WEST SUSSEX COUNTY COUNCIL CONSULTATION

TO:	Arun District Council FAO: A Gardner
FROM:	Highways, WSCC
DATE:	21 st November 2018
LOCATION:	Shell Eastfield, Worthing Road, Wick, Littlehampton, BN17 6LE
SUBJECT:	LU/314/18/PL Demolition of sales building & plant room, LPG compound/dispenser & canopy link removed, erection of new sales building, plant room, bin store, delivery bay, front of store customer parking & Adblue facility to the HGV forecourt, block pavements to car forecourt replaced with liquid tight concrete & fuel dispensers replaced to main forecourt & HGV.
RECOMMENDATION:	☐ Advice ☐ Modification ☒ More Information ☐ Objection ☐ No Objection ☐ Refusal
S106 CONTRIBUTION TOTAL:	£N/A

TITLE : SITE LAYOUT PLAN (1:100) as proposed

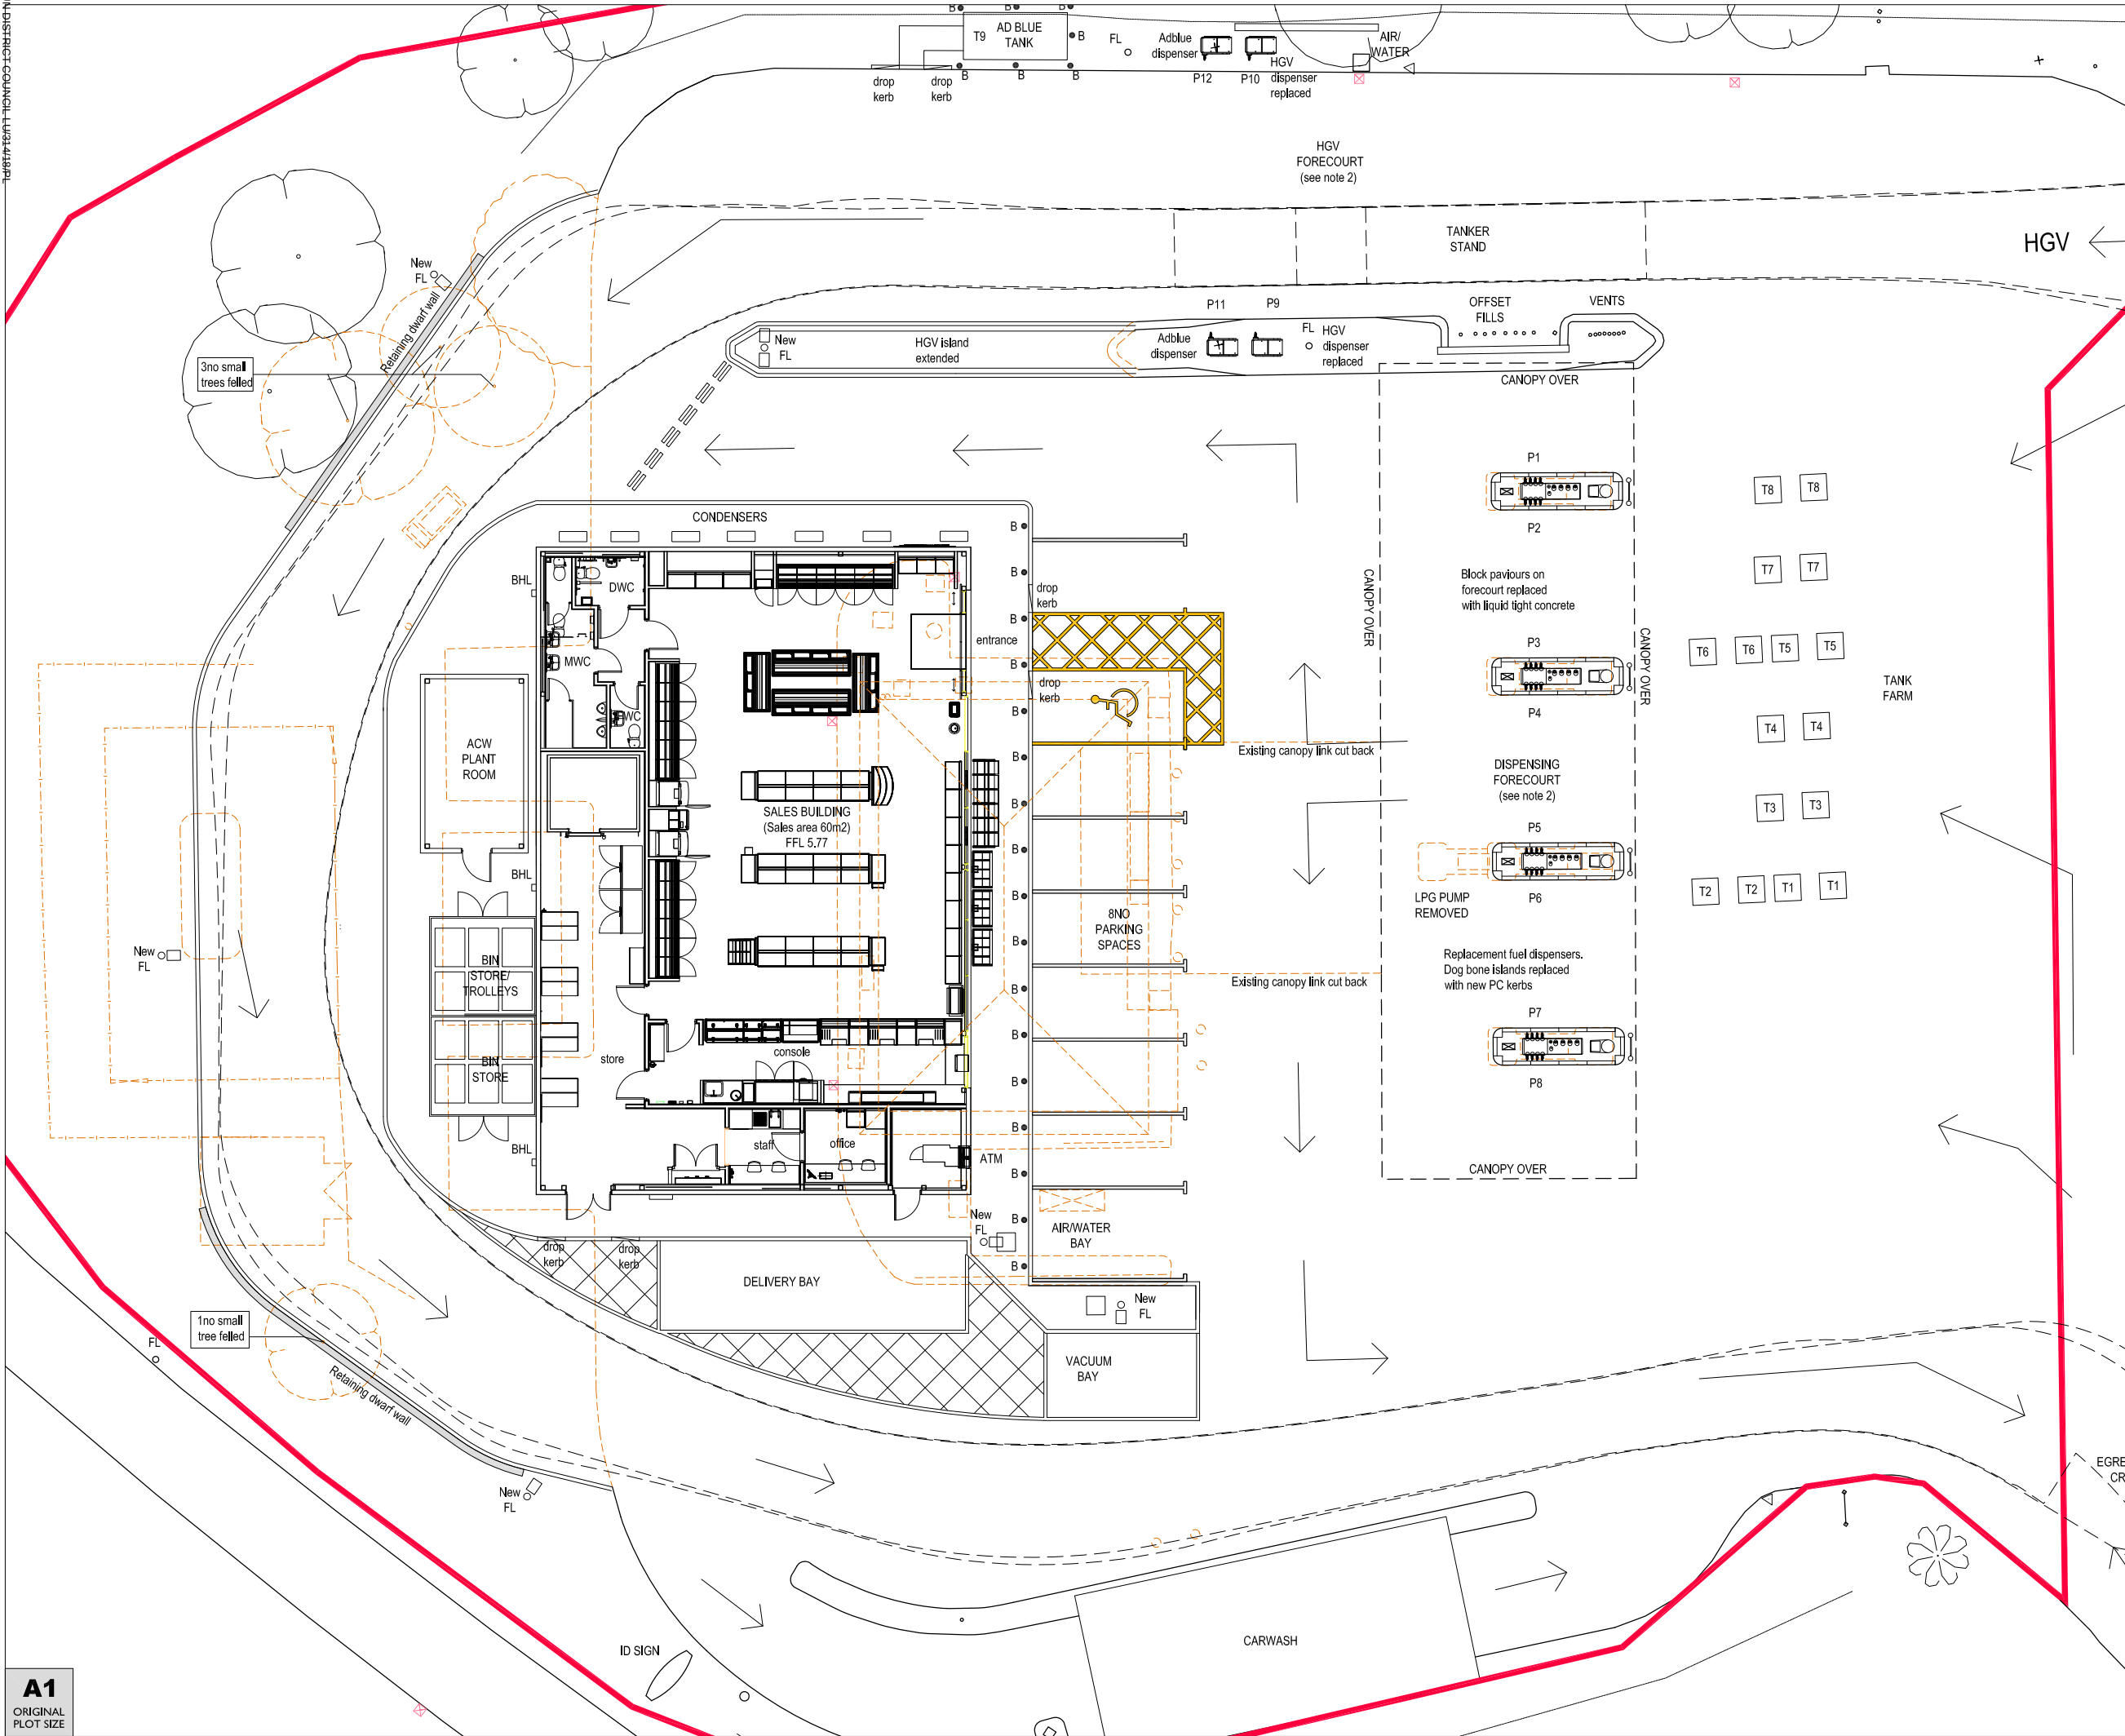
No changes to the existing vehicular access points from the A259 and from Worthing Road (B2187) are proposed and no additional changes to the forecourt layout or petrol pumps are proposed. The new layout will not affect the existing HGV forecourt accessed via the A259. Whilst there are slight modifications to the HGV route through and out of the site, the plans demonstrate the workability of this and also indicate a delivery bay to the south of the building, clear of the public parking area.

The new sales building will be enlarged with a retail area of 160 sqm. Under WSCC Supplementary Planning Guidance (adopted Nov 2003) a food retail use could see a maximum demand for 1 car parking space per 14 sqm. On this basis 11 spaces could be provided total. Nevertheless the LHA are mindful of the drop-in nature of the retail element and that the majority of customers will be purchasing fuel also. Furthermore the proposals seek to formalise some amount of car parking, including a disabled marked bay, air/water bay and vacuum bay. This is an improvement over the existing situation where no formalised car parking appears to be in place. Nevertheless there does not appear to be any allocated staff parking spaces, where will staff parking take place – will the new bays be utilised for this?

Considering the nearby cycle lane and ability to reach the site by sustainable modes of transport, the LHA advise that secure cycle parking be provided for staff/ customers who may live nearby and wish to utilise the shop.

- Will any dedicated staff parking be provided?
- What is the luminance and size of proposed signs?
- Will bicycle parking be included?

TITLE: SIGNAGE PLAN as proposed

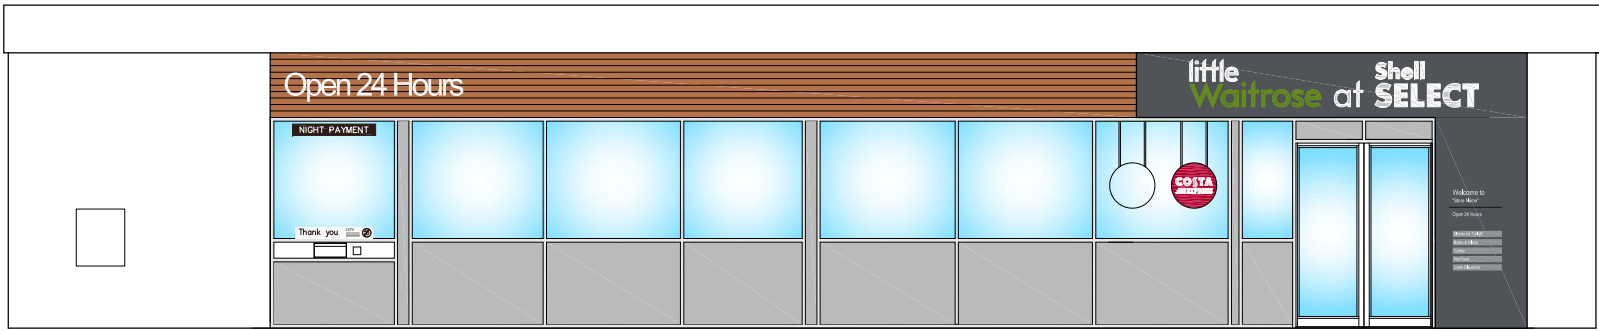
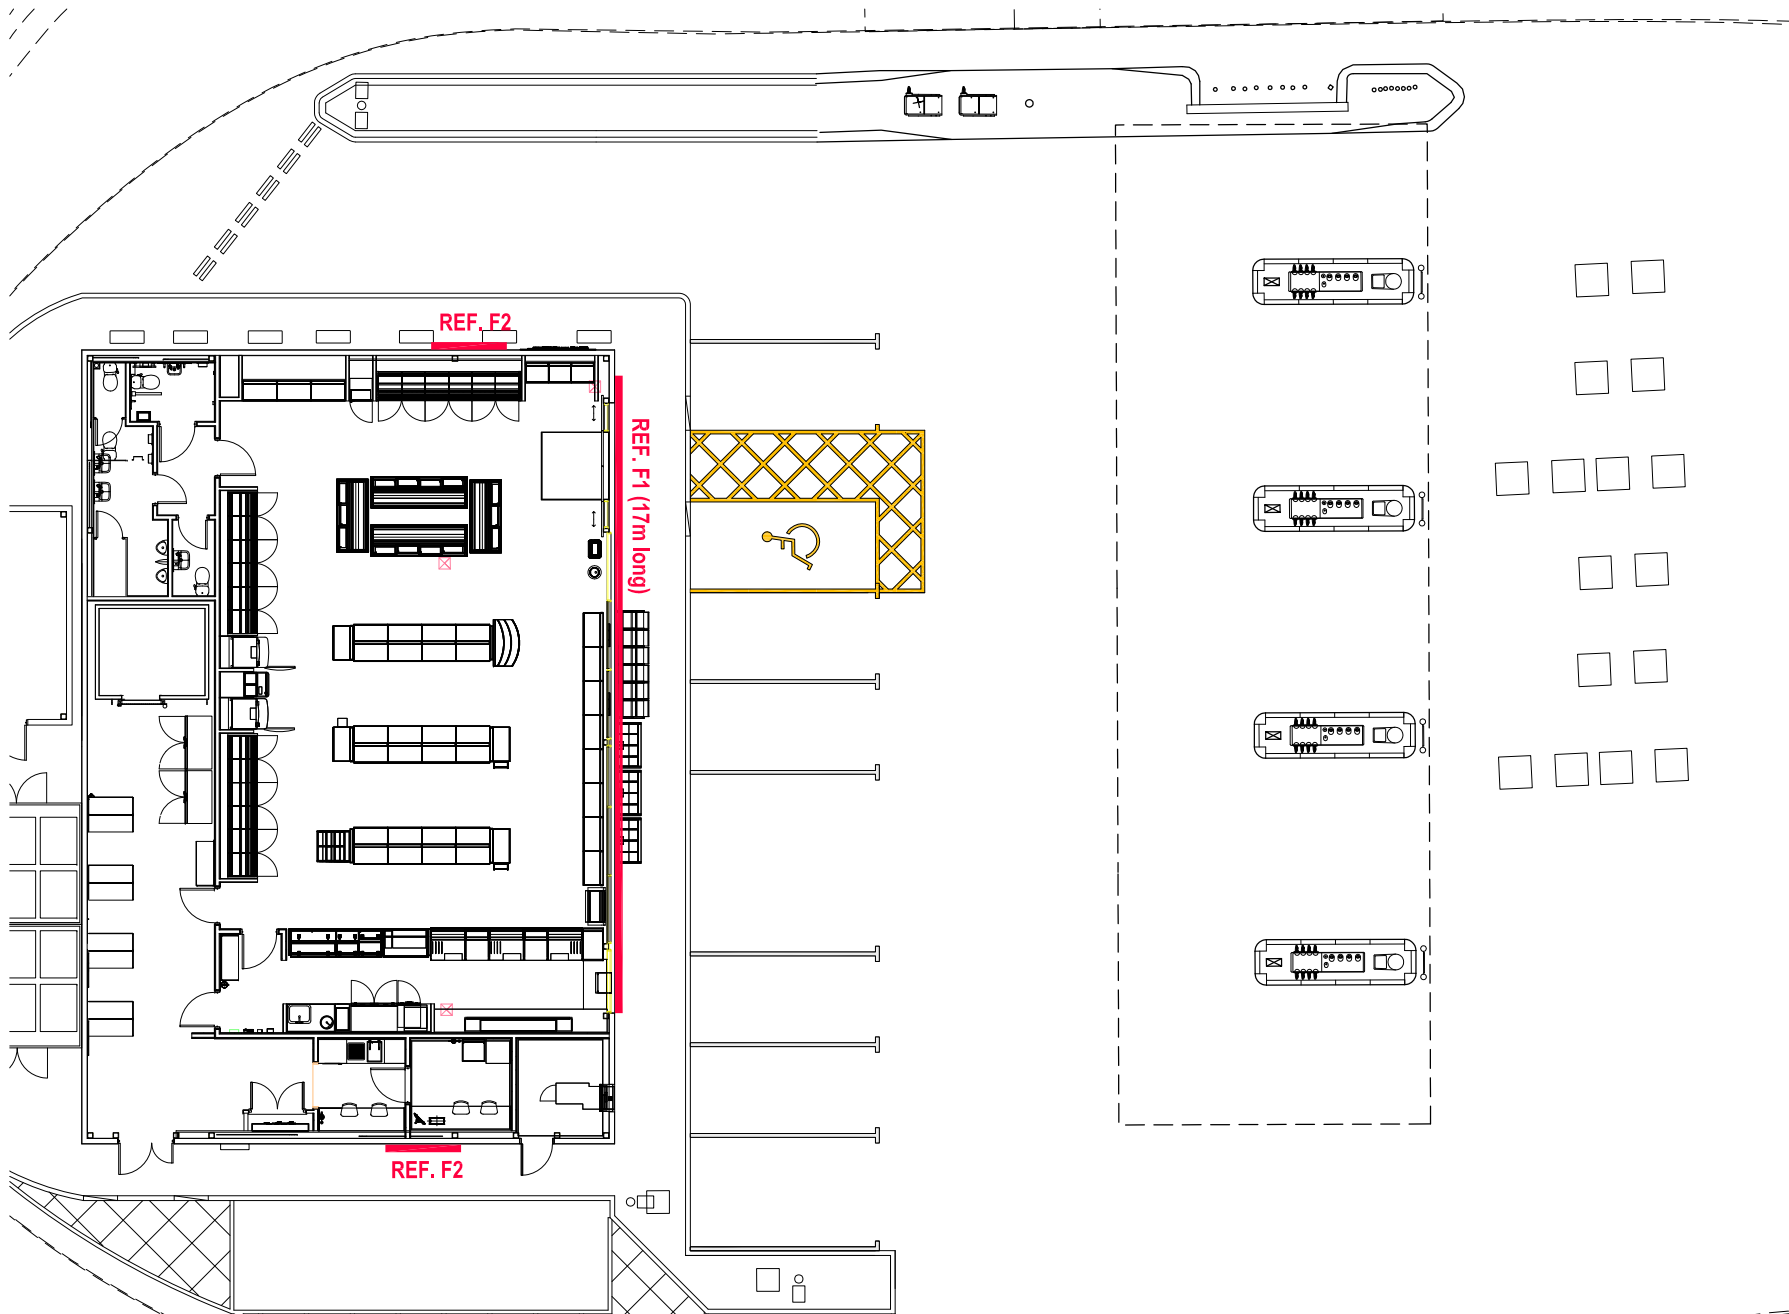
I note some internally illuminated signage is proposed on the new building, some of which may be visible from the public highway. Provisionally, there would be no highway objection to these signs, providing they do not exceed 800 cd/m². The applicant should confirm the size and luminance level of these.
